APPENDIX 1: North Falls Offshore Wind Farm: Environment Agency's Response to the Examining Authority's 2nd Written Questions (ExQ2)

Your Ref: EN010119

Our ref: AE/2025/130509

APPENDIX 2: North Falls Offshore Wind Farm: Environment Agency's comments on [REP4-032] 9.46 Flood Risk Assessment (Clarification regarding flood risk associated with watercourse crossings) - Technical Note, and · [REP4-033] Flood Risk Assessment (Updated NaFRA2 dataset) - Technical Note (Rev 0)

Legend

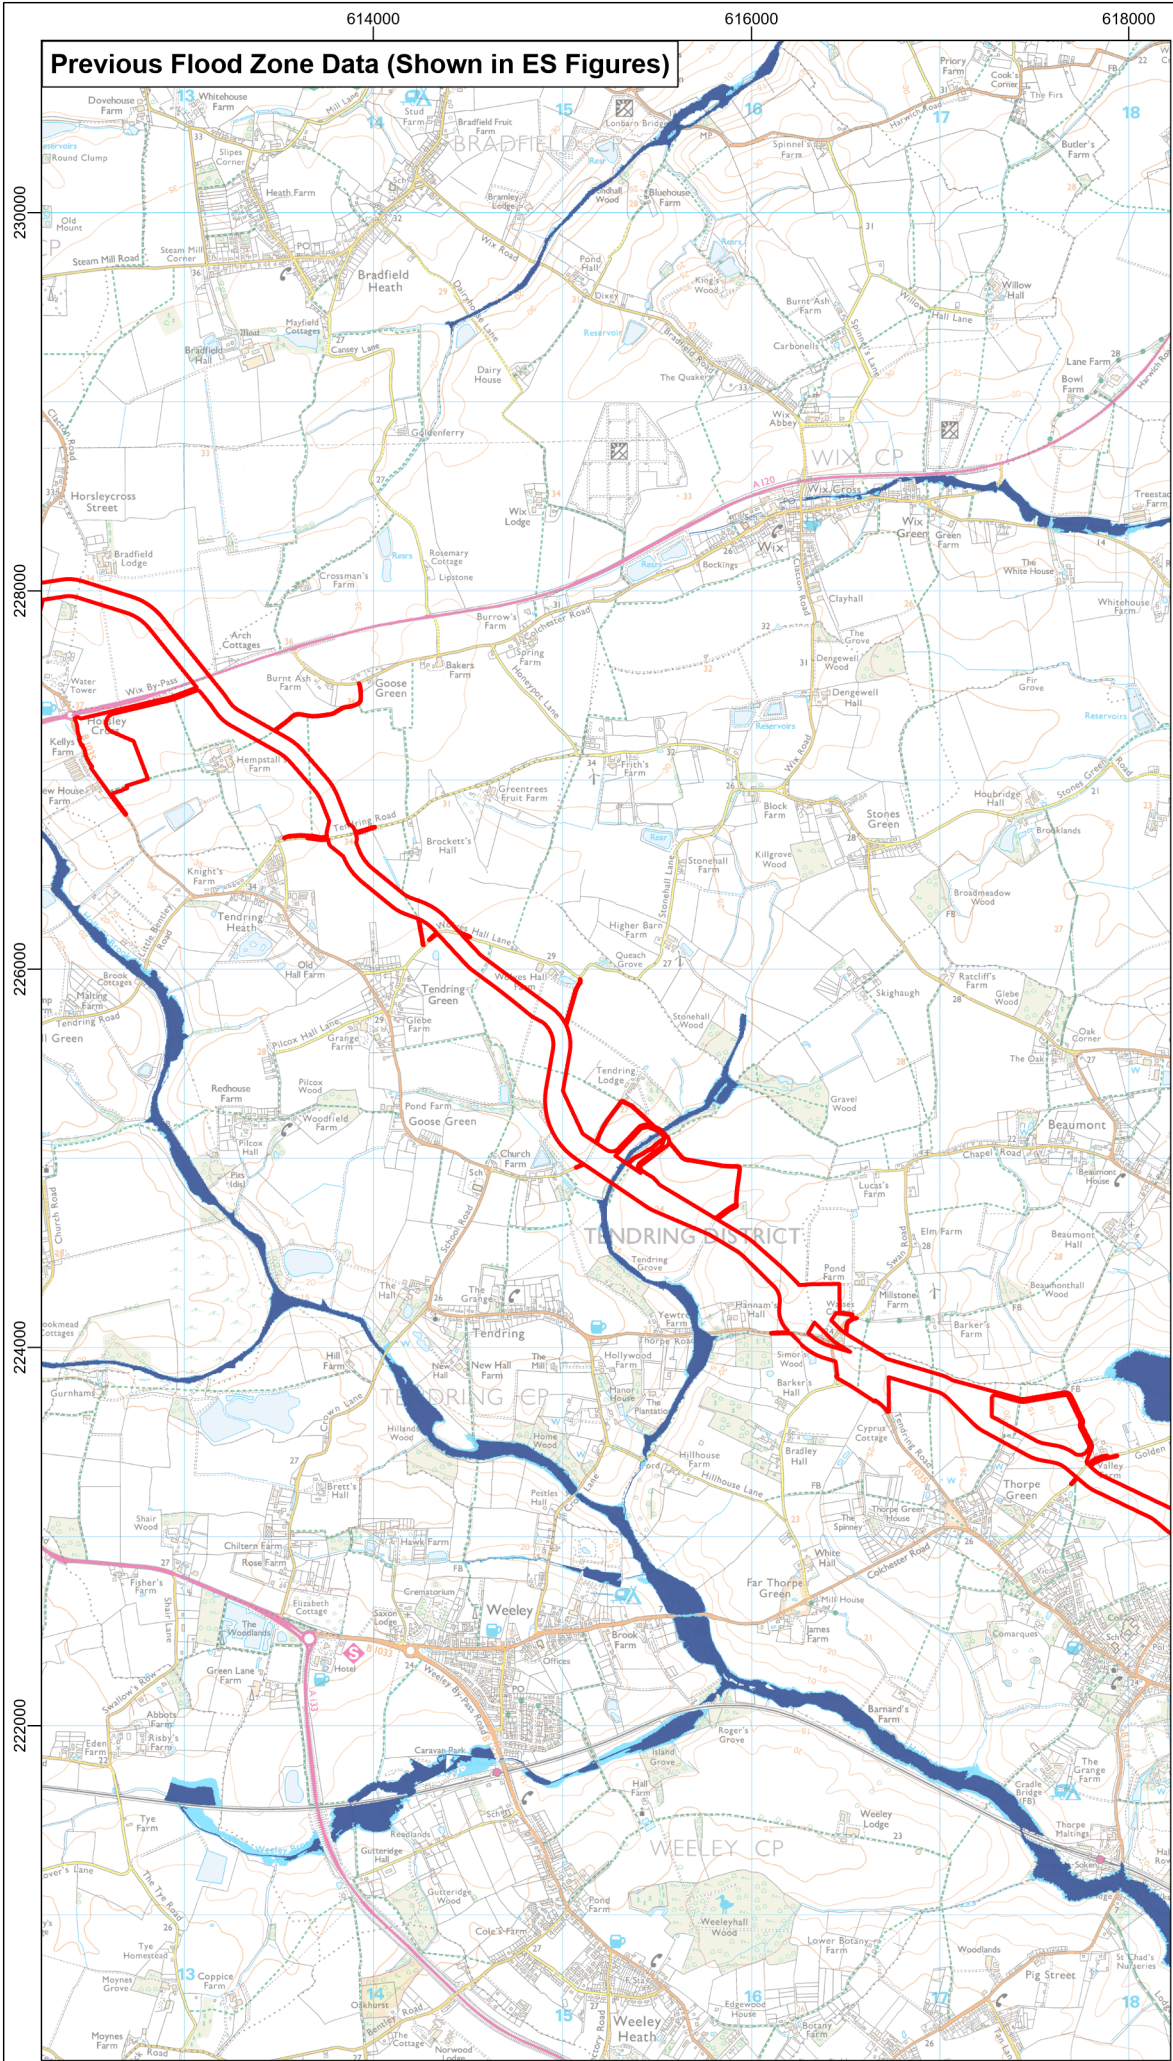
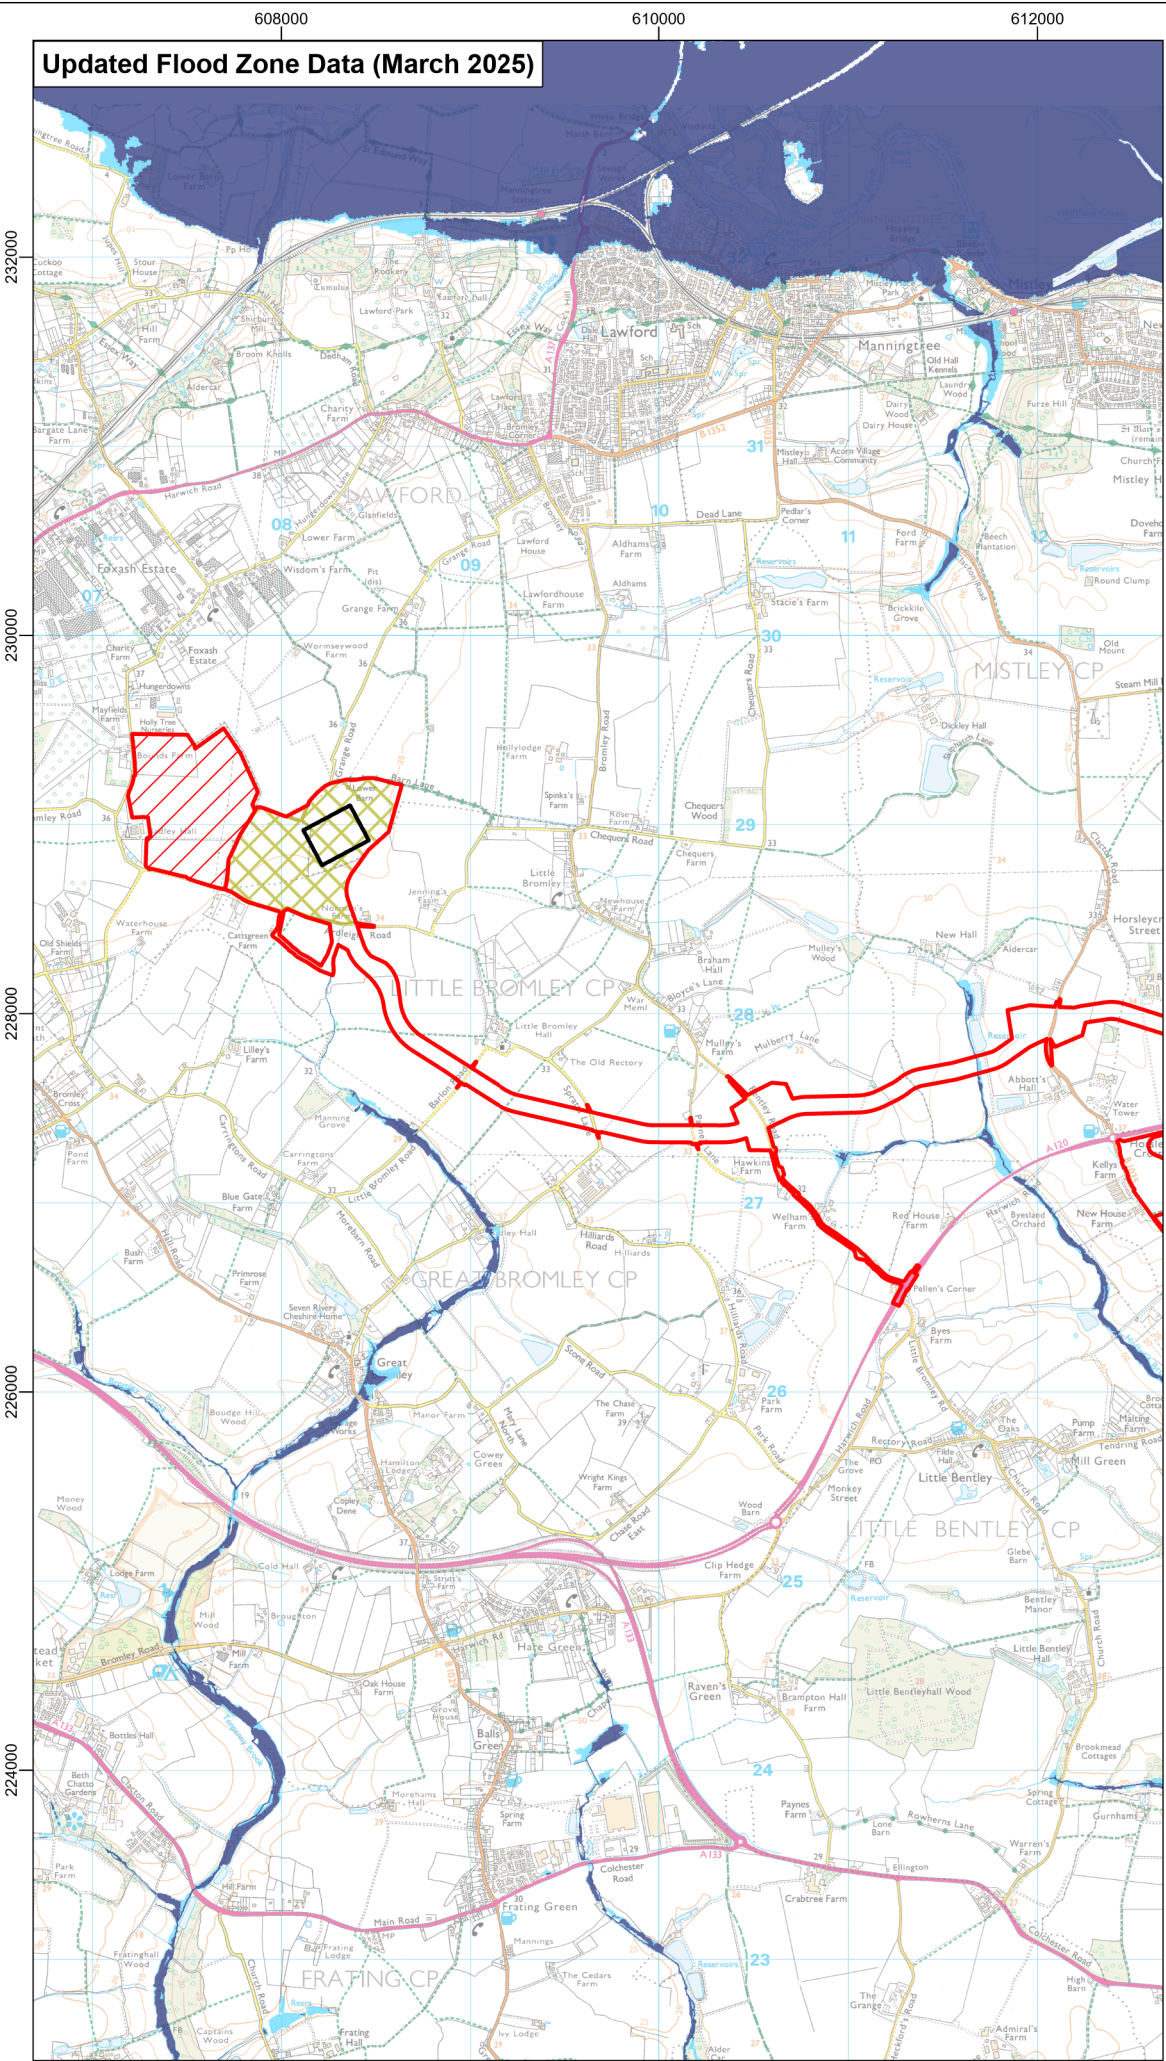
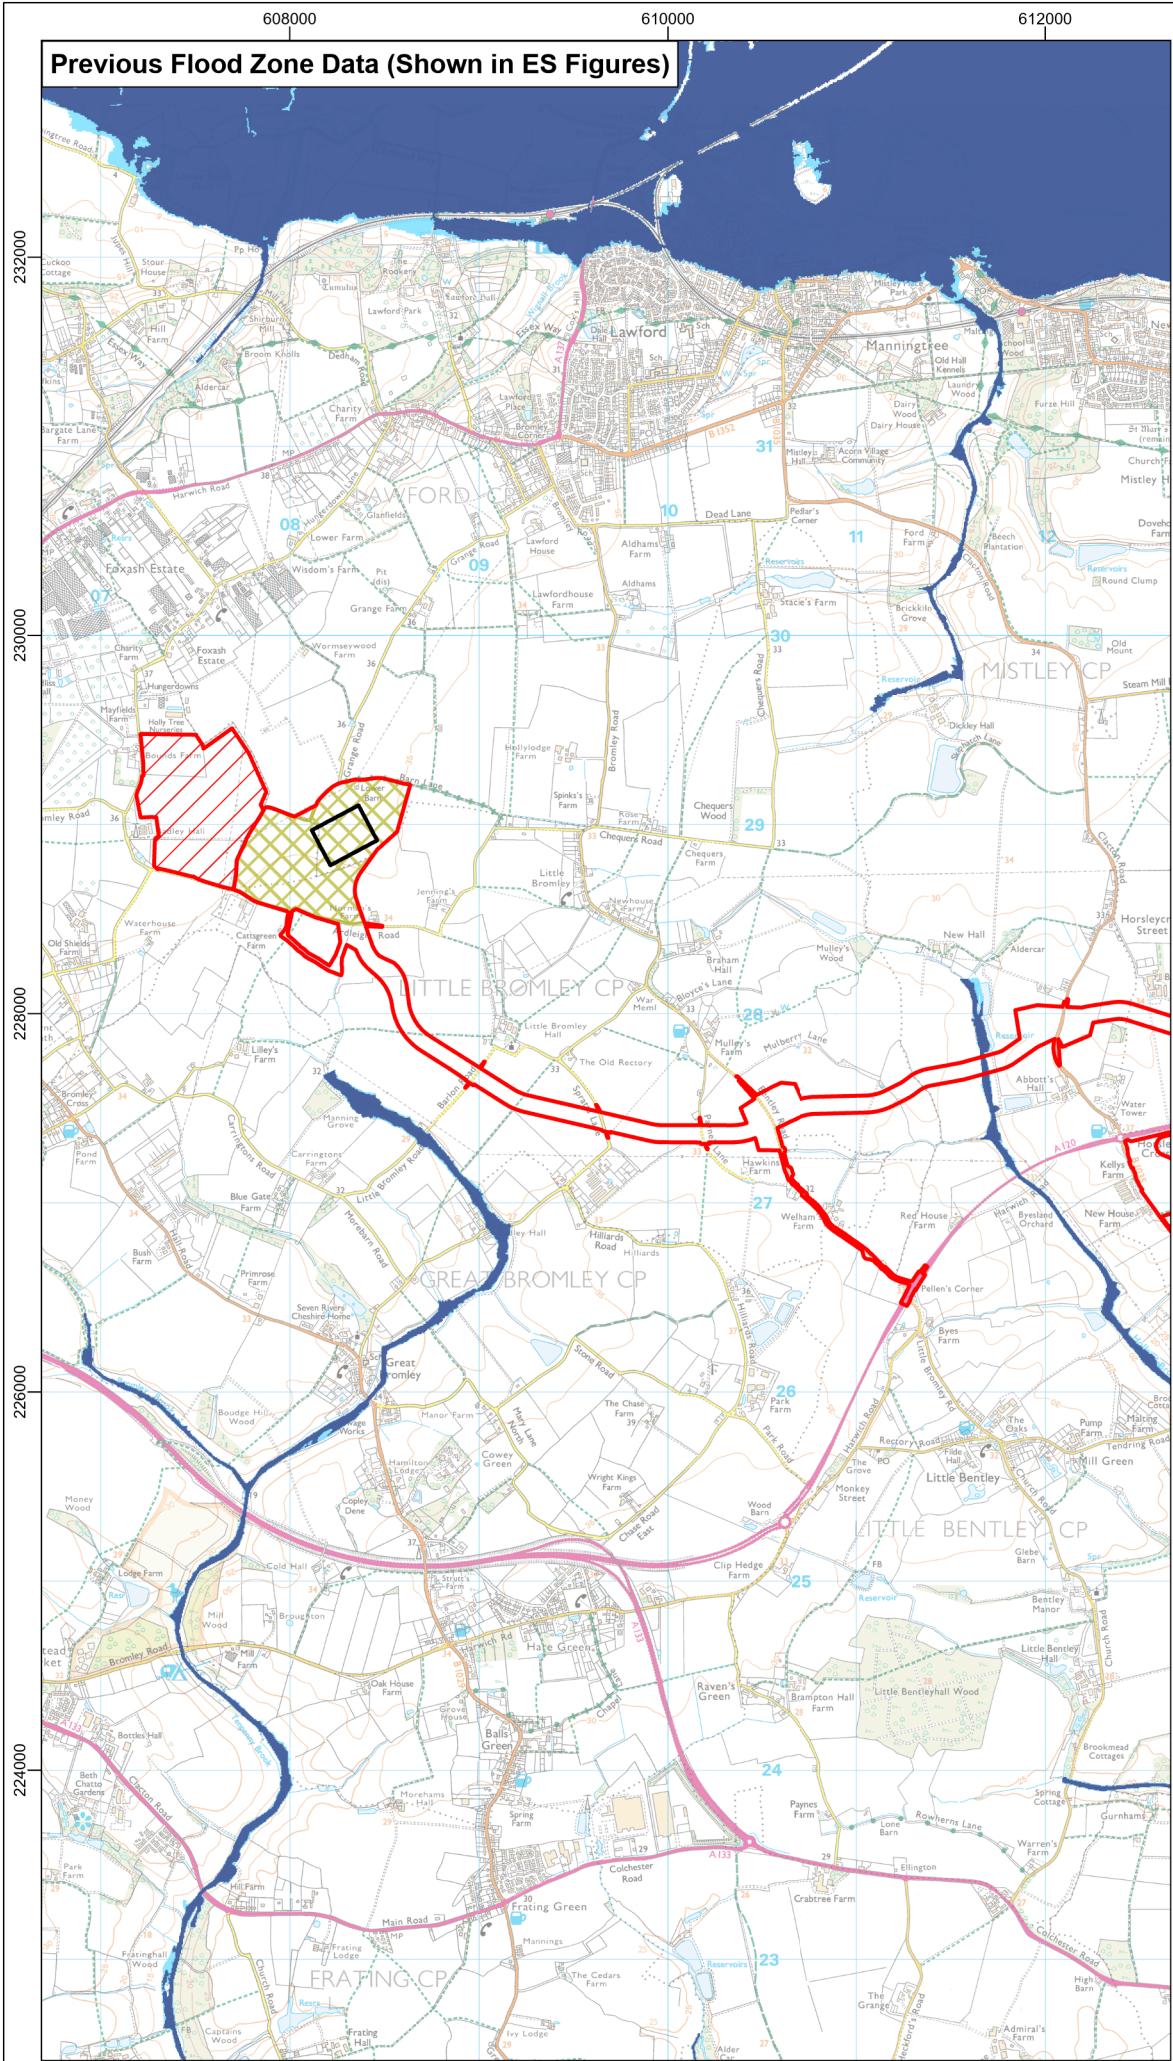
Following submission of the North Falls DCO application in July 2024, the Environment Agency published new national risk information for flooding and coastal erosion. Following a review of the updated Flood Zone extents against previous Flood Zone data used in ES Appendix 21.3 Flood Risk Assessment [APP-121] (see Figure 3.1 and Section 3.1), it is considered that there are no significant changes in the Flood Zone extents across the entire onshore project area. This includes the landfall, onshore cable route and onshore substation works area.
